# Appeal Decision

**Appeal Ref: APP/R5510/D/24/3336344**

**90 Wimborne Avenue, Hayes, UB4 0HH**

- The appeal is made under section 78 of the Town and Country Planning Act 1990 against a refusal to grant planning permission.
- The appeal is made by Mrs. Shakila Maan against the decision of the Council of the London Borough of Hillingdon.
- The application Ref 44670/APP/2023/3174, dated 2 November 2023, was refused by notice dated 28 December 2023.
- The development is described as retention of rear conservatory extension.

<i>Name</i>		<i>SITE ADDRESS</i>	
Ms. Shakila Maan		90 Wimbourne Avenue Hayes. UB4 0HH	
<i>TITLE</i>			
<i>Existing Elevations</i>			
<i>SCALE</i>	<i>DATE</i>	<i>DWG NO</i>	<i>Rev</i>
1:100	June 2023		
		NM90WA03

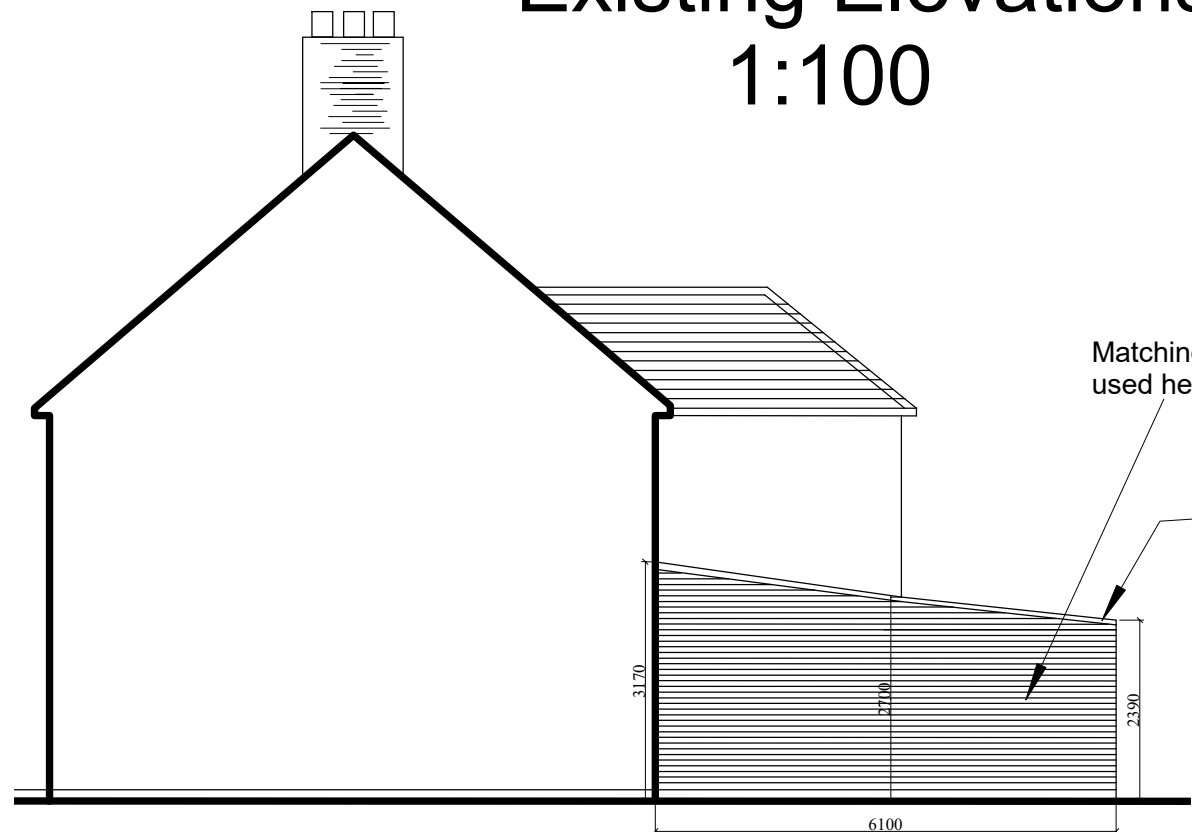
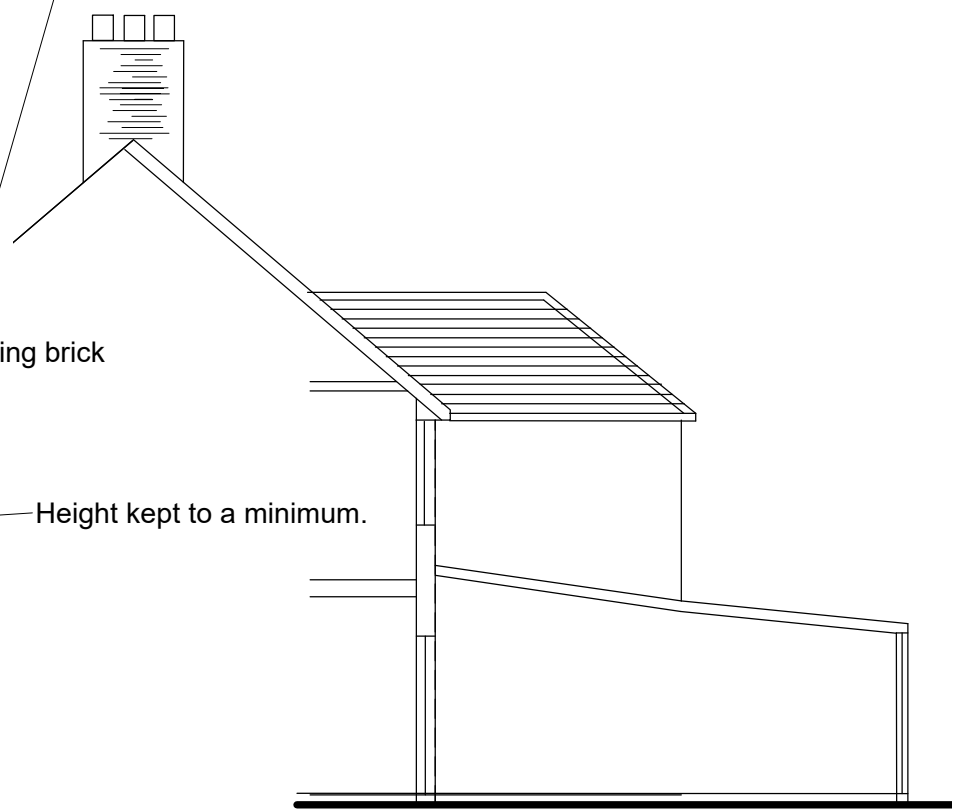
6. A concrete post and timber fence runs along the boundary separating Nos 88 & 90, and the extension replaced a short length of this. I could see that the side wall of the conservatory was higher than the solid fence, but not by much, and the wall is not so high in comparison as to give rise to the consequences alleged by the Council. The outlook from the ground floor window of No 88 closest to the appeal property is already affected by No 90's existing single storey extension, and the new extension, of a slightly lower height, has little or no effect on this aspect. That the newly built extension is only marginally higher than the existing fence means that whilst a small section could be seen above the level of the fence from within No 88 and its garden, its visual impact would be minimal and not unacceptable.
